REQUEST

Current Zoning: B-D (CD) AIR (distributive business, conditional, airport noise overlay)
Proposed Zoning: I-1 (CD) AIR (light industrial, conditional, airport noise overlay)

Approximately 105 acres located between Shopton Road and Beam Road.

The petition proposes to permit the development of a vacant parcel with up to 1,250,000 square feet of gross floor area of warehousing, warehouse distribution, manufacturing, office, and industrial uses.

## SITE PLAN

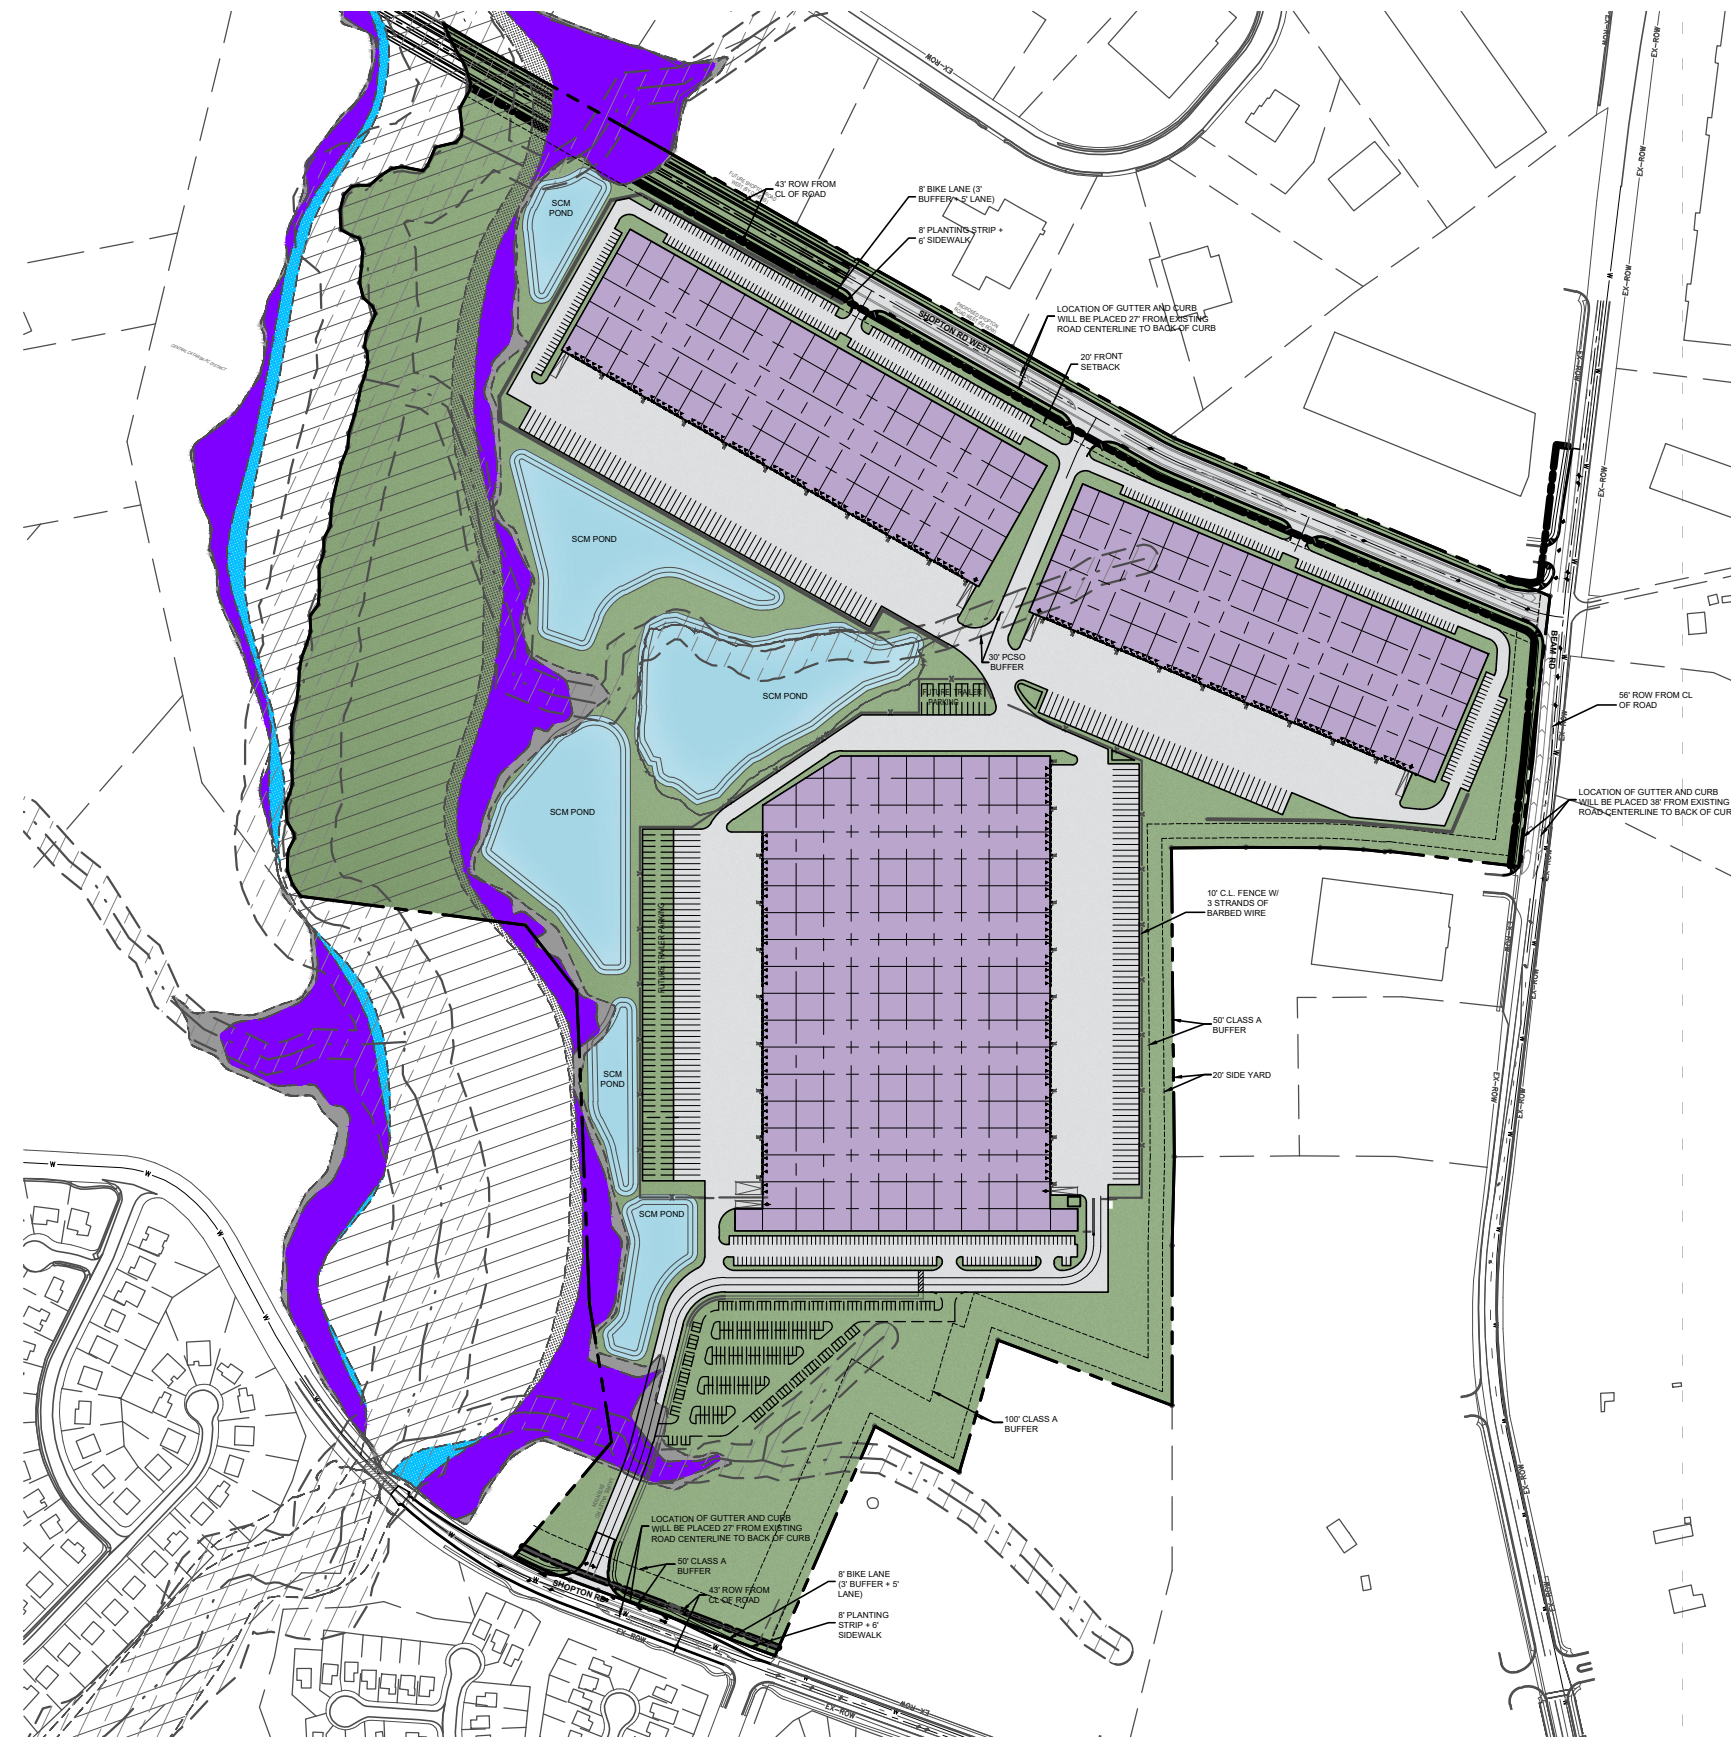
2. ~~Revise conditional note III.i by modifying the phasing of the Beam Road transportation improvements. All the transportation improvements on Beam Road shall be completed prior to the Shopton Road Extension is connected to Beam Road.~~ **ADDRESSED**

3. ~~Remove the "1/" from the building area square footage on site plan notes.~~ **ADDRESSED**
4. ~~Depict and label the buffer adjacent to Beam Road as 50' Class A. Correct corresponding note V.b.~~ **ADDRESSED**
5. ~~Depict and label the buffers along the eastern and southeastern property boundaries as 100' Class A. Correct corresponding note V.a.~~ **ADDRESSED**
